CITY OF ALBUQUERQUE

May 7, 2024

**Re: Hope Christian High School
Neighborhood Impact Analysis, HT#D18D009
Report dated April 29, 2024
Engineer's Stamp ---
Via email JCIIGroup@gmail.com**

TRAFFIC CIRCULATION LAYOUT

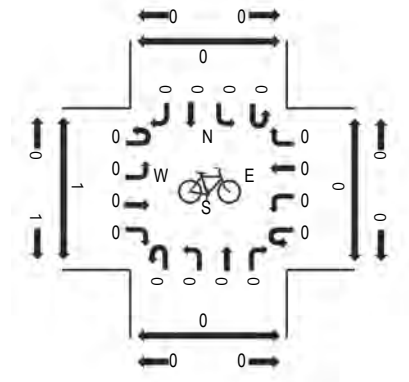
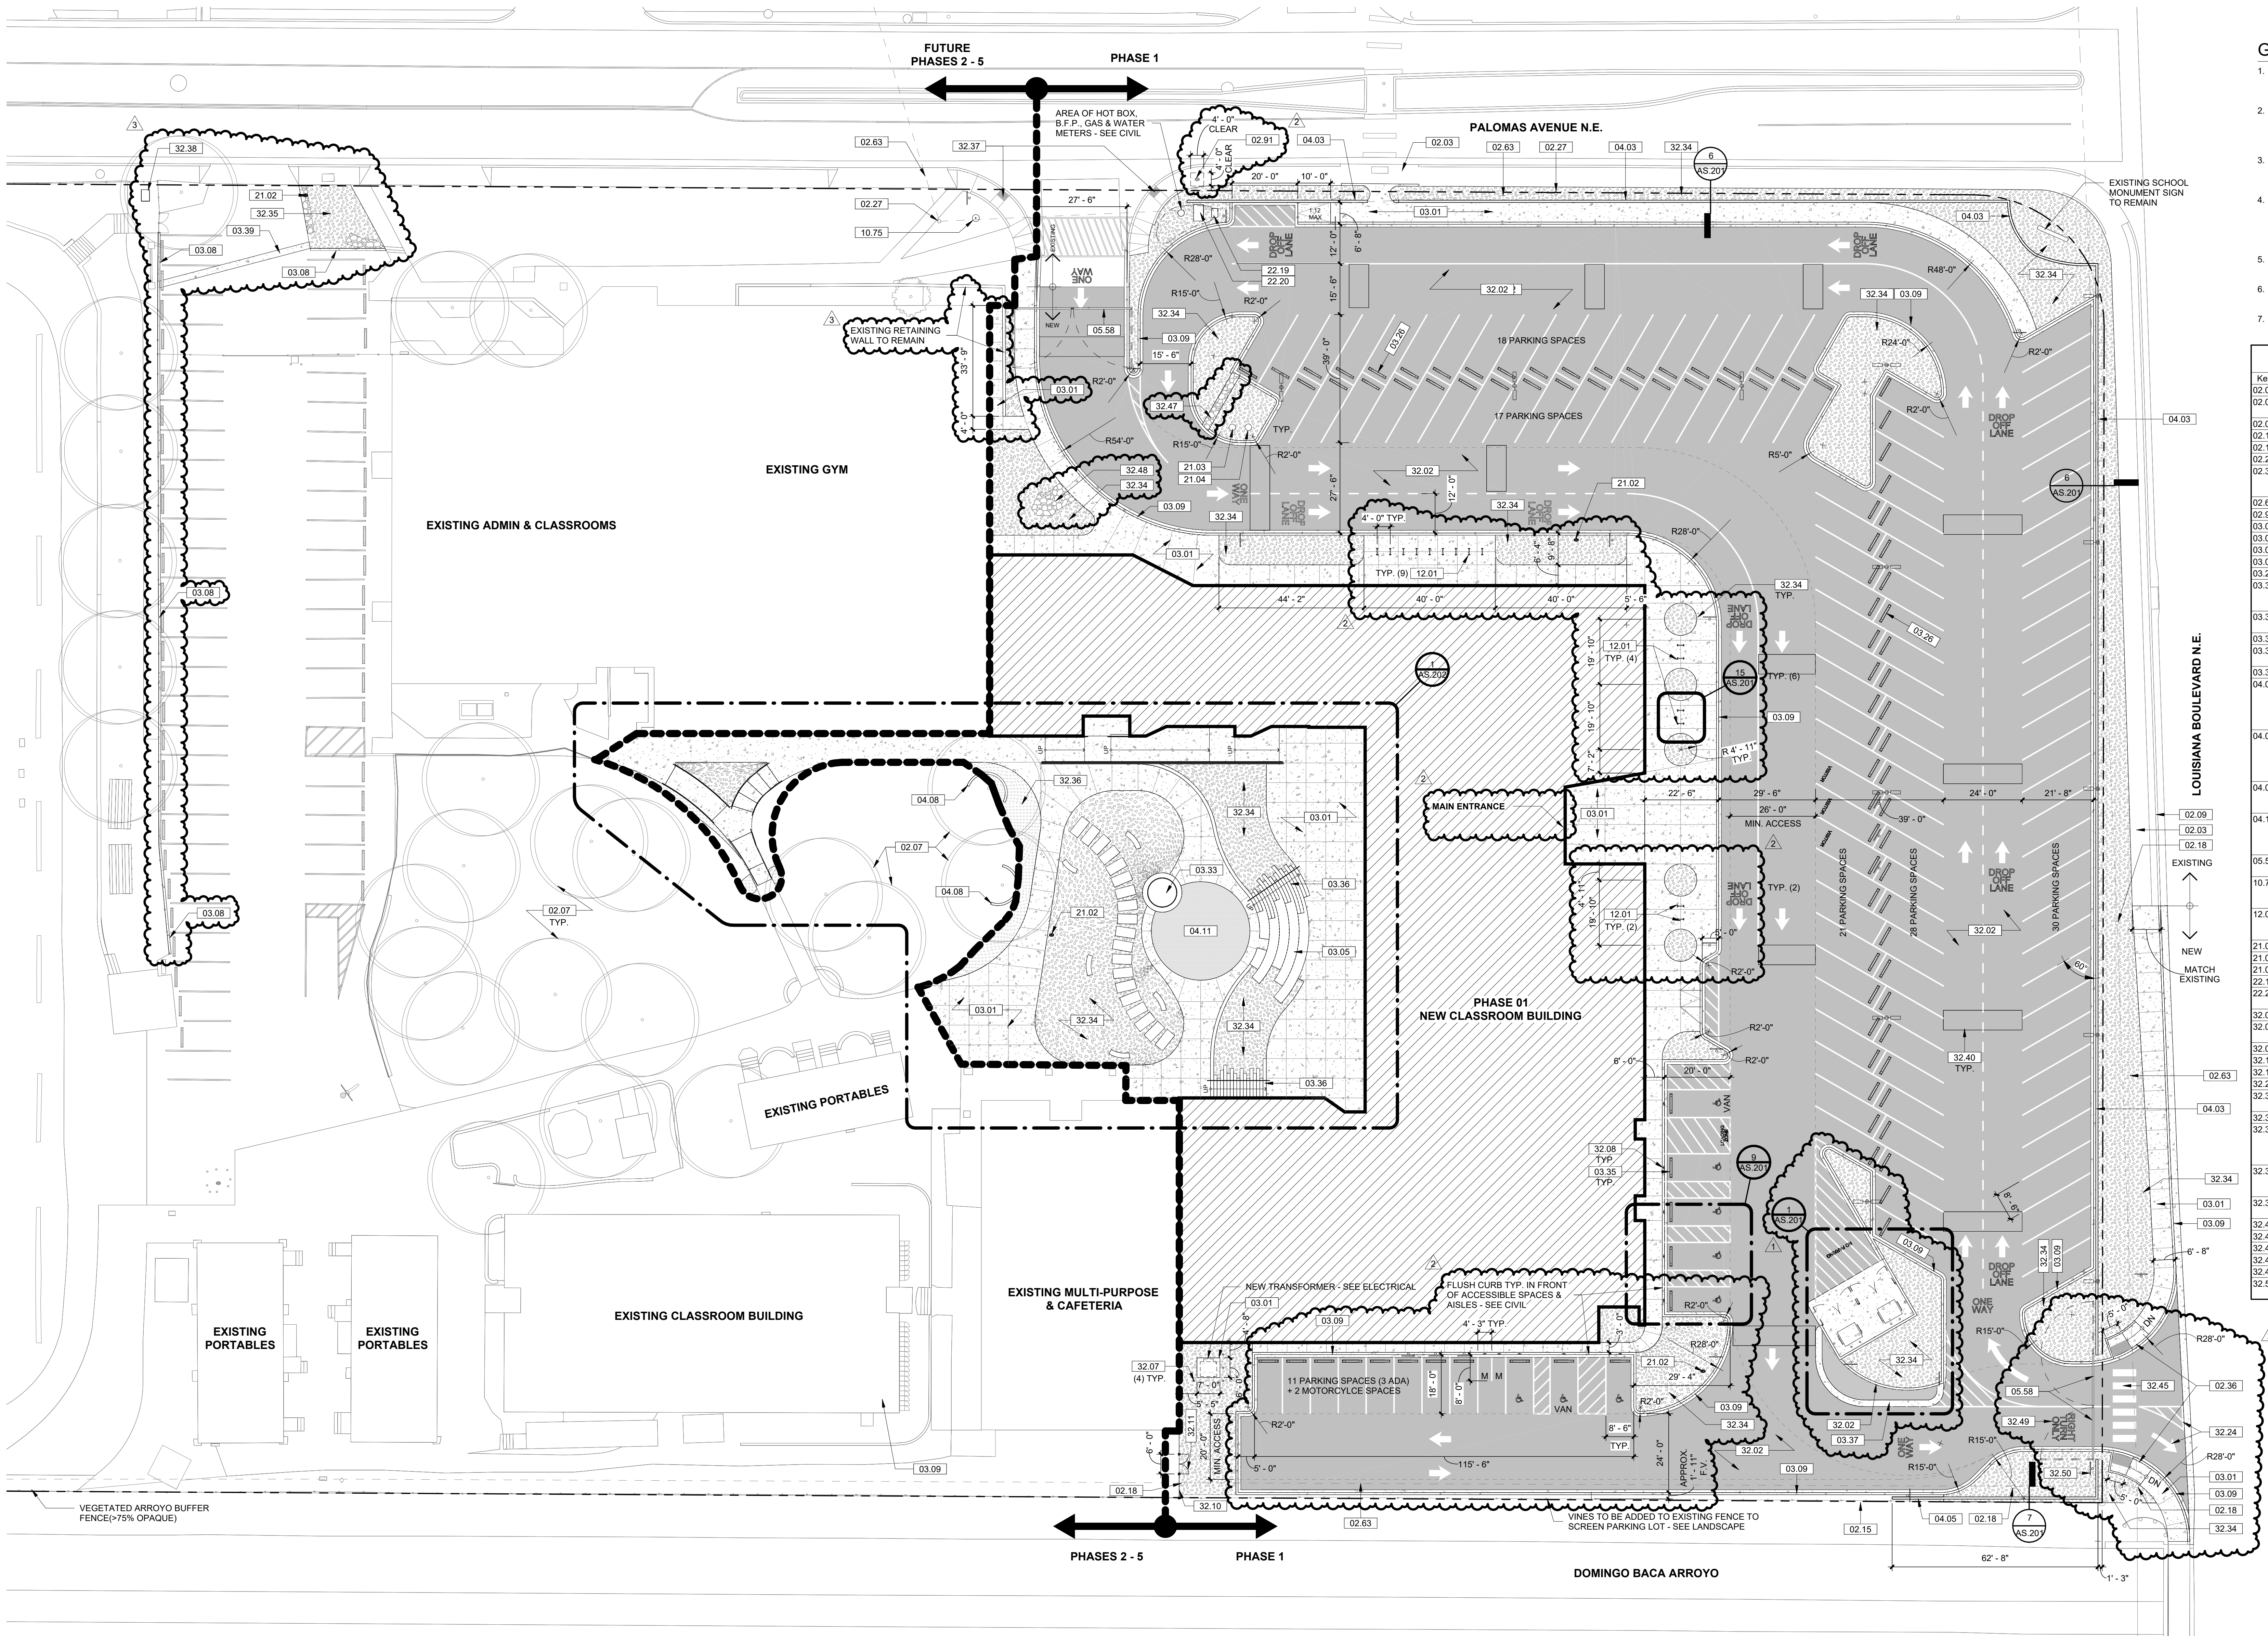
1. Revise the striping of the northbound Two-way Left-turn lane on San Pedro Dr. approaching the proposed Hope Christina School south driveway to a left-turn lane. Adjust the southbound left-turn lane striping at the access to the FAA facility on the east side of San Pedro D., across from the proposed Hope Christian school access.

2. Convert the two-existing crosswalk on Palomas Ave. to Raised Crosswalks/Speed tables. Refer to <https://nacto.org/publication/urban-street-design-guide/street-design-elements/vertical-speed-control-elements/speed-table/>

3. Refer to Part 7, Traffic Control for School Areas, of the of the MUTCD and consult with the City of Albuquerque DMD Traffic Operations to establish and properly sign and mark the School Zones on Palomas Dr.

4. On Palomas Ave. in locations where there are raised medians and curb extensions on-street parking is prohibited. Consider using pavement marking words (No Parking) or crosshatching in the no parking zone in addition to the painted curbs and parking restriction signs. In areas where there is illegal on-street parking, parking enforcement should be enhanced to reduce the parking violations. Below is an image, in front of the elementary school, from Google Earth showing what appears to be parking in the no-parking zone with painted curbs.
